Recommendation Report for Planning Permission for Works or Extension to a Dwelling

REF NO: AB/44/21/HH

LOCATION: Fern Cottage
5A Surrey Street
Arundel
BN18 9DT

PROPOSAL: Proposed loft conversion (This application may affect the setting of the Arundel Conservation Area).

Proposed Loft Conversion Plans and Elevations Planning Date March 2021 Scale 1:50

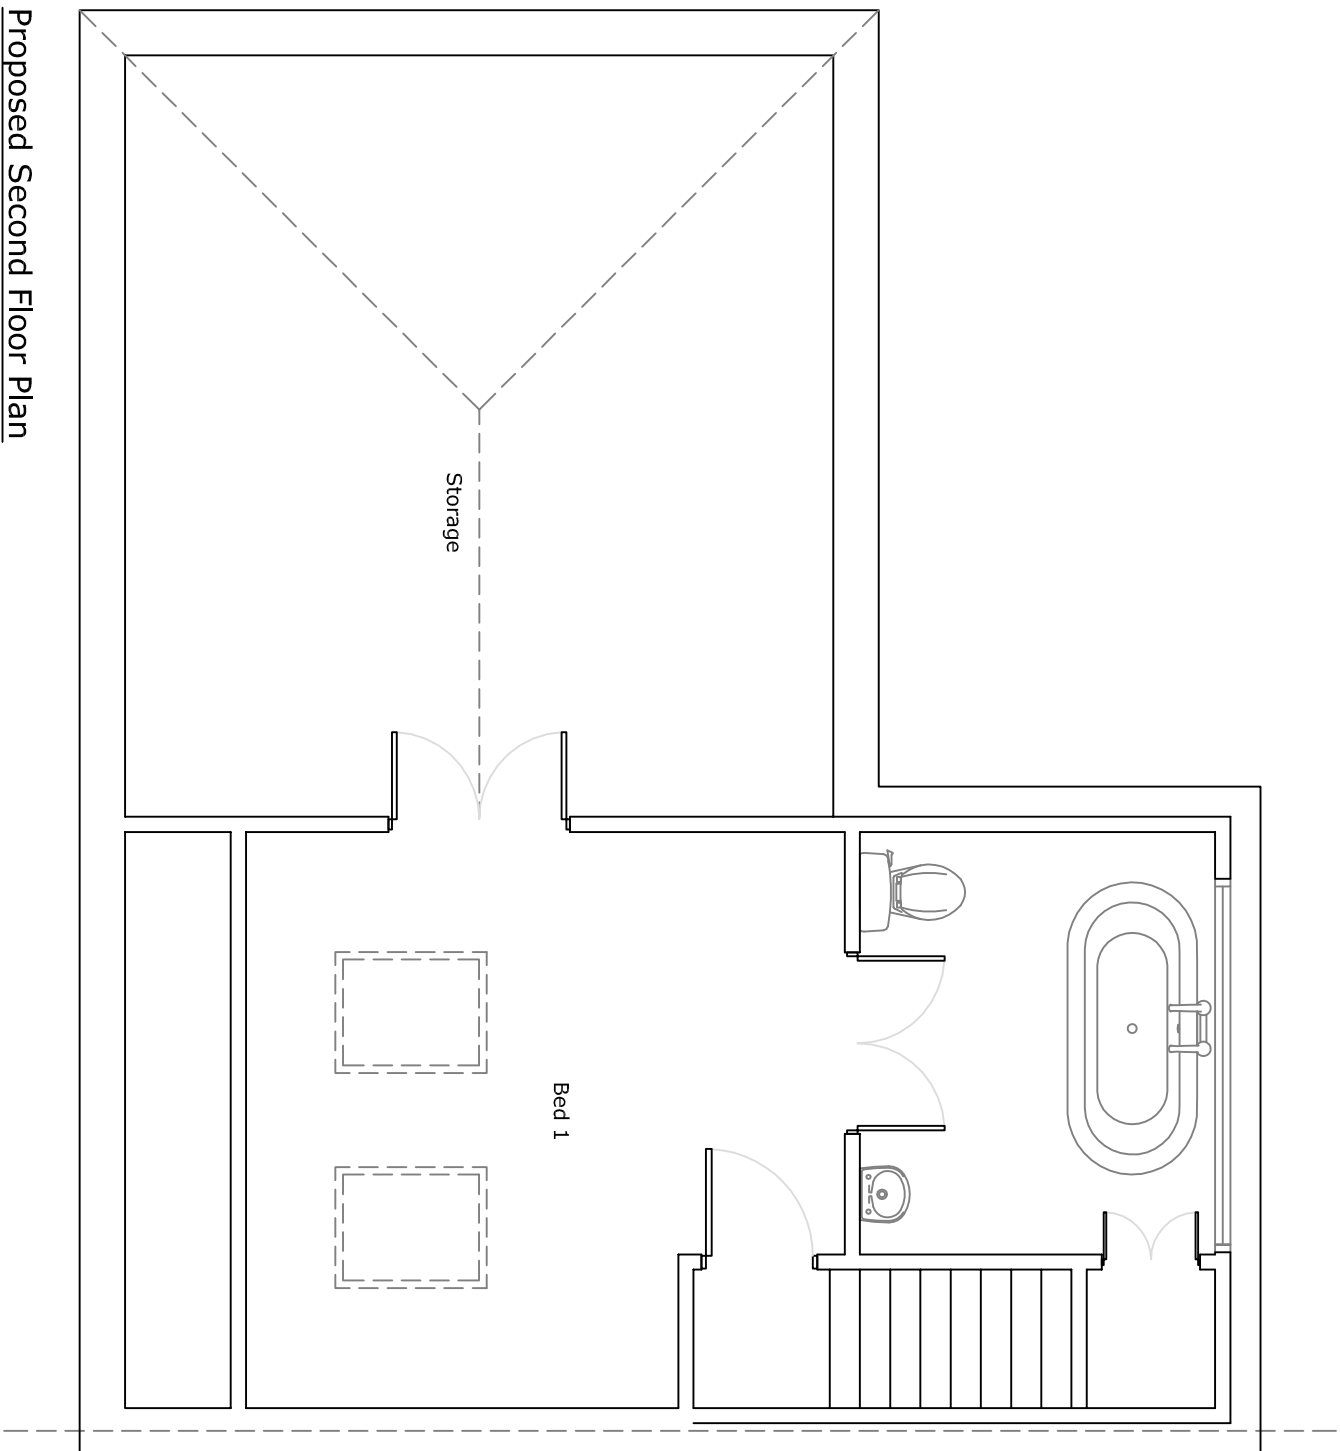
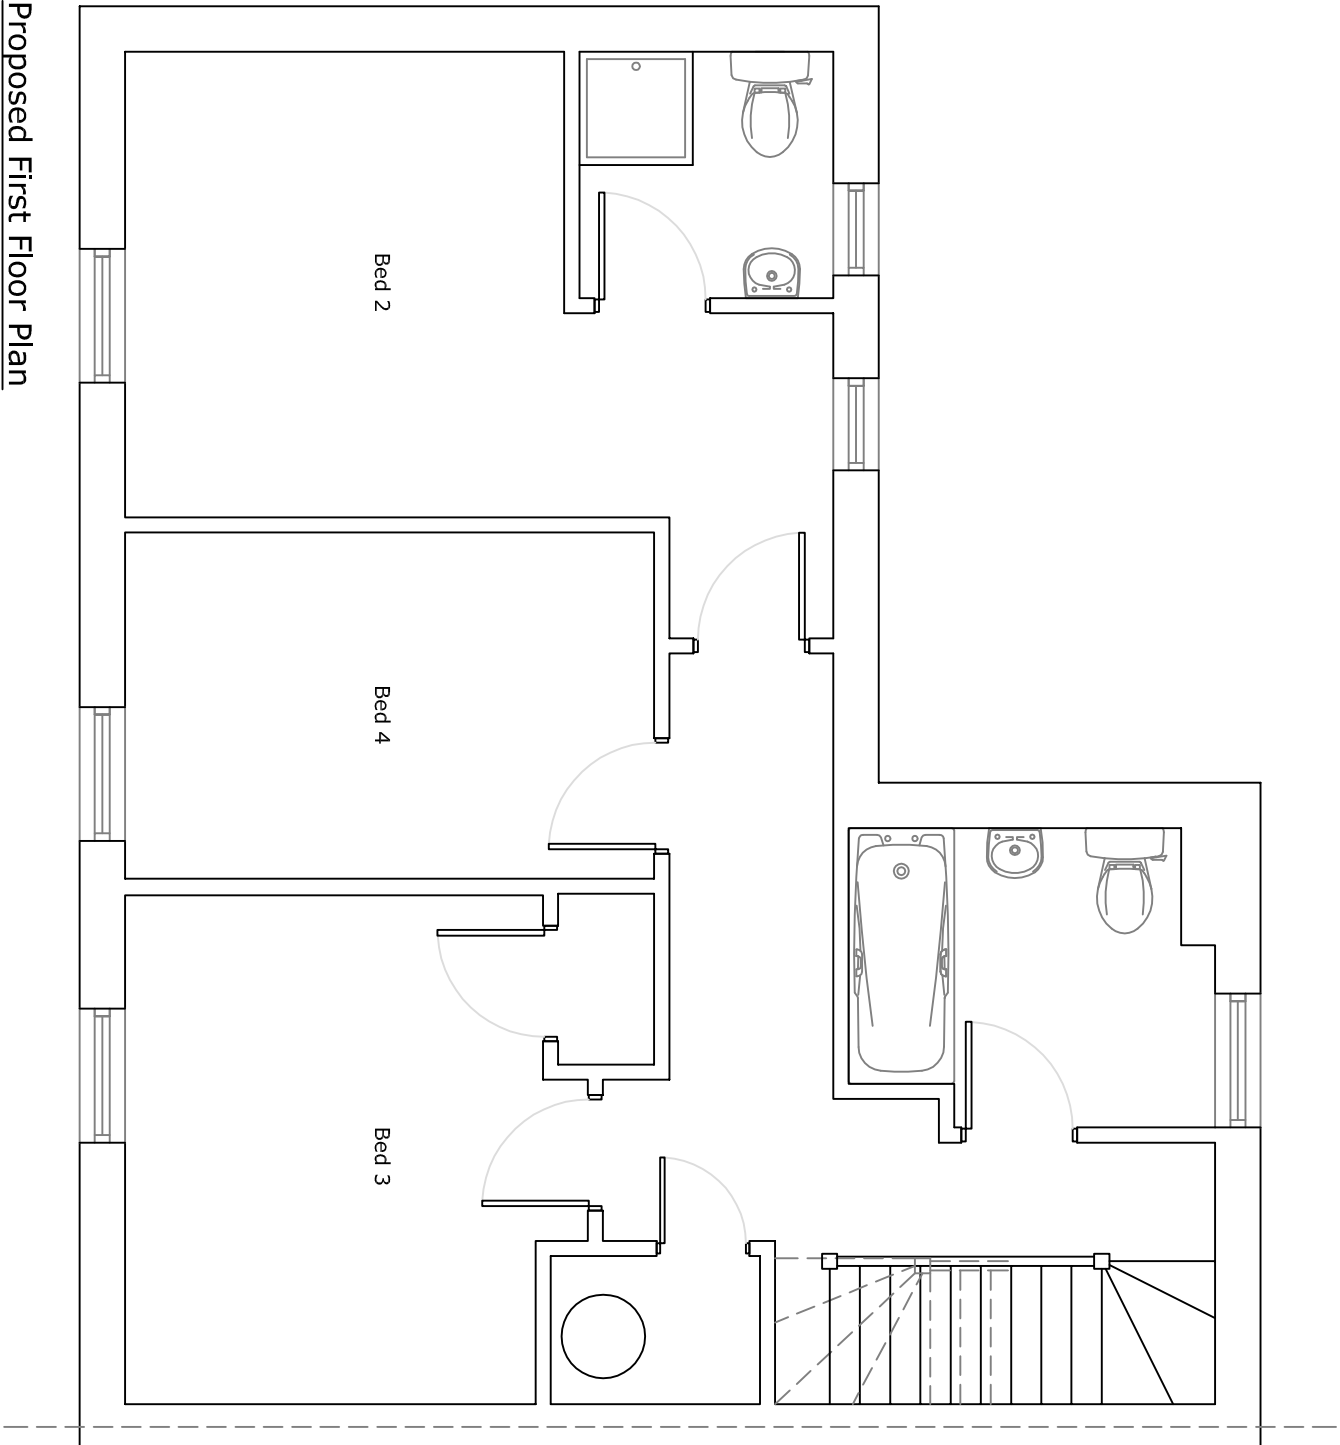
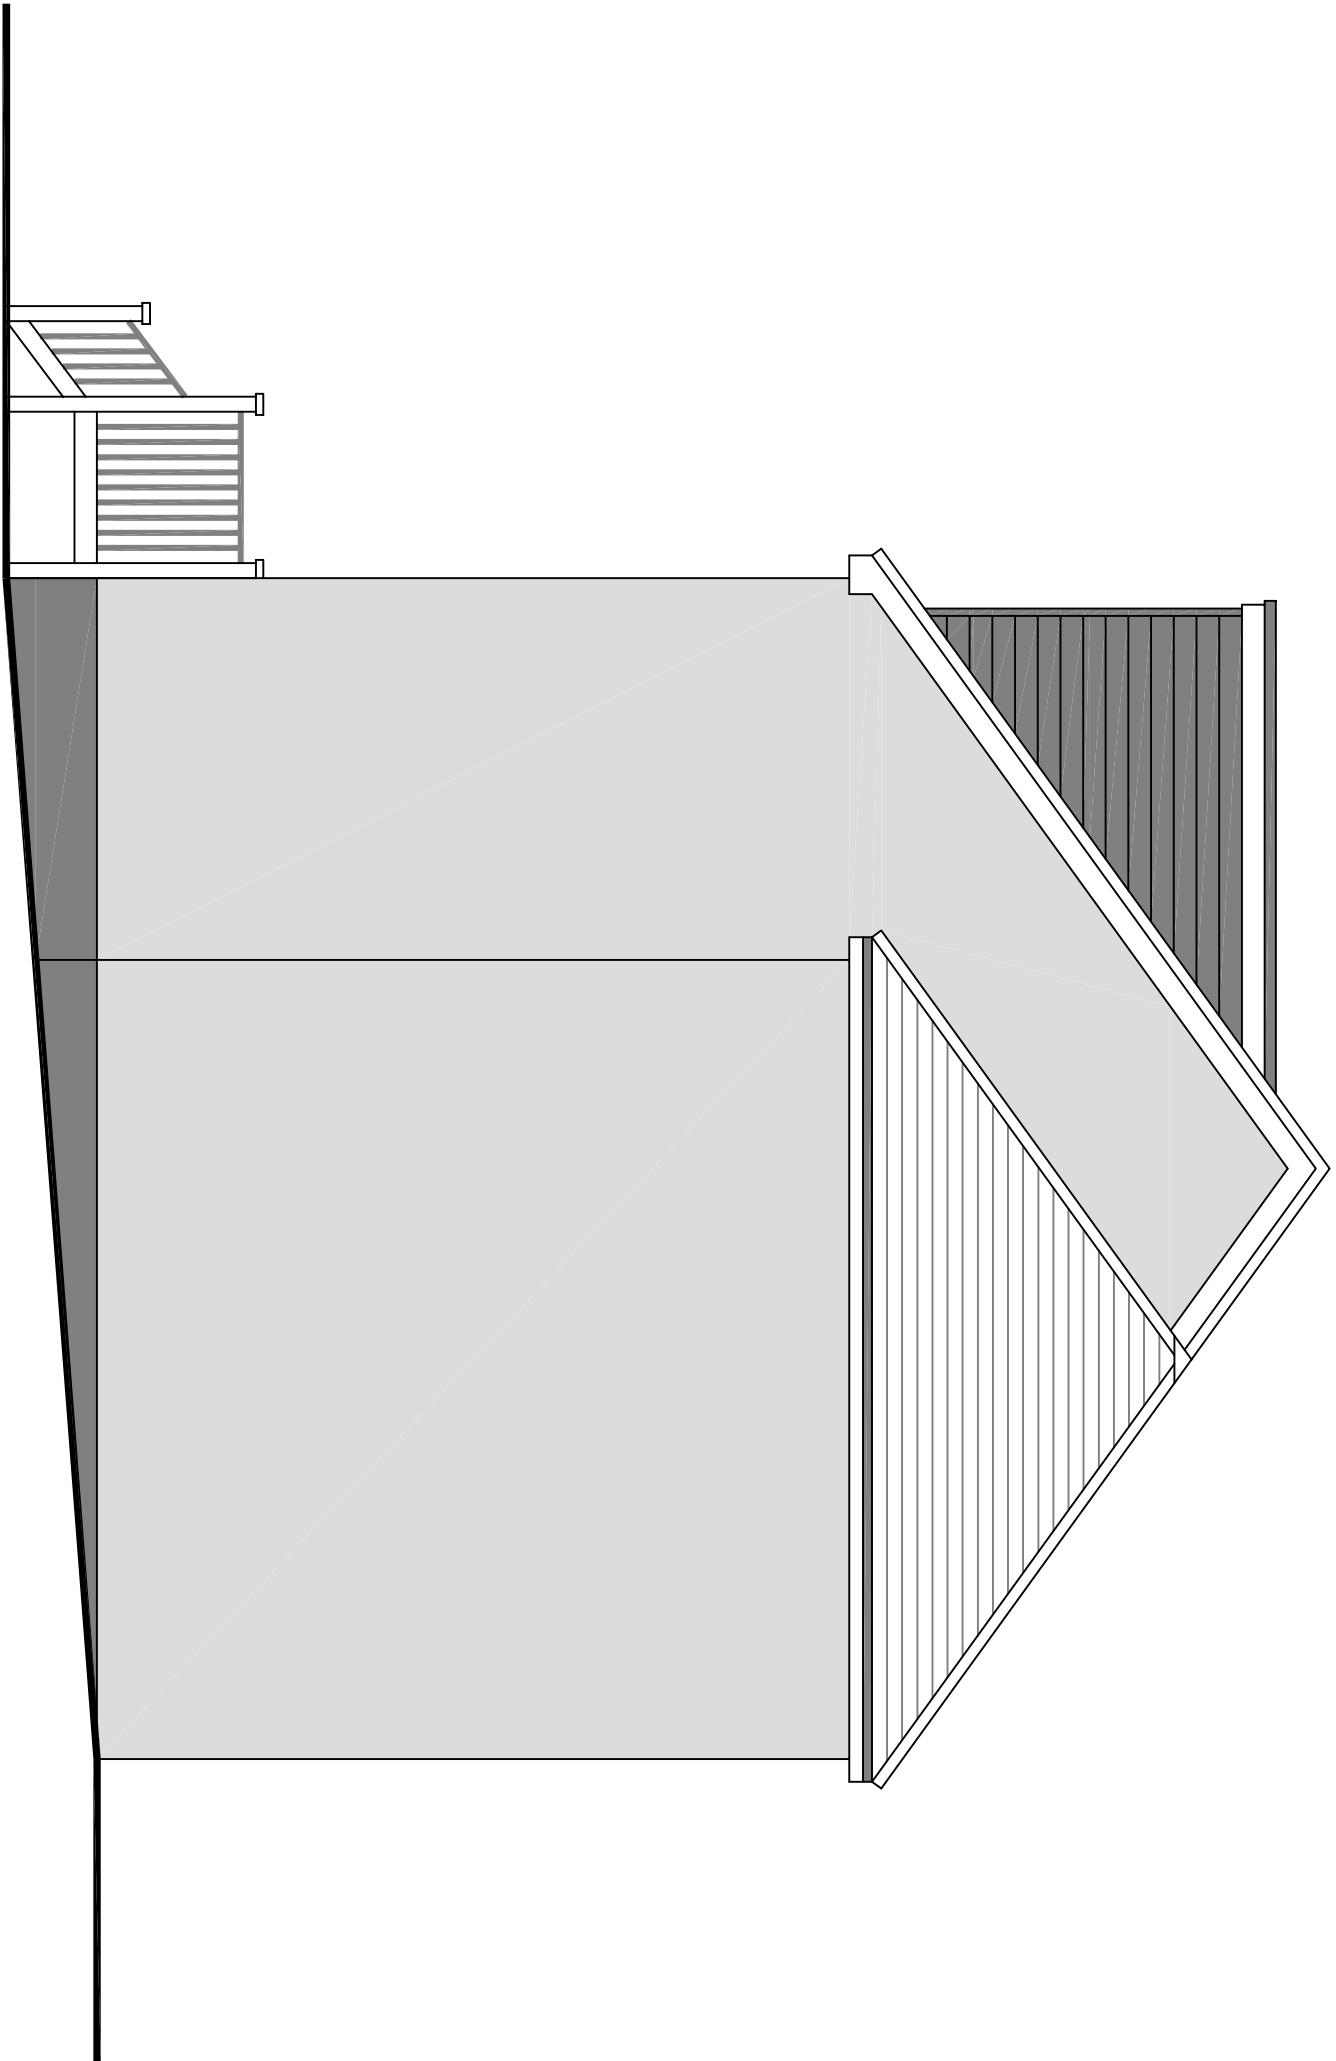
ADC Conservation Advisory Panel - Objection
-Change to roof shape will appear incongruent within street scene.
-Very large rooflights will detract from appearance of street scene and the setting of the listed buildings.
-Conflict with policy relating to protection of conservation area.
-Plans show inconsistencies with existing windows.
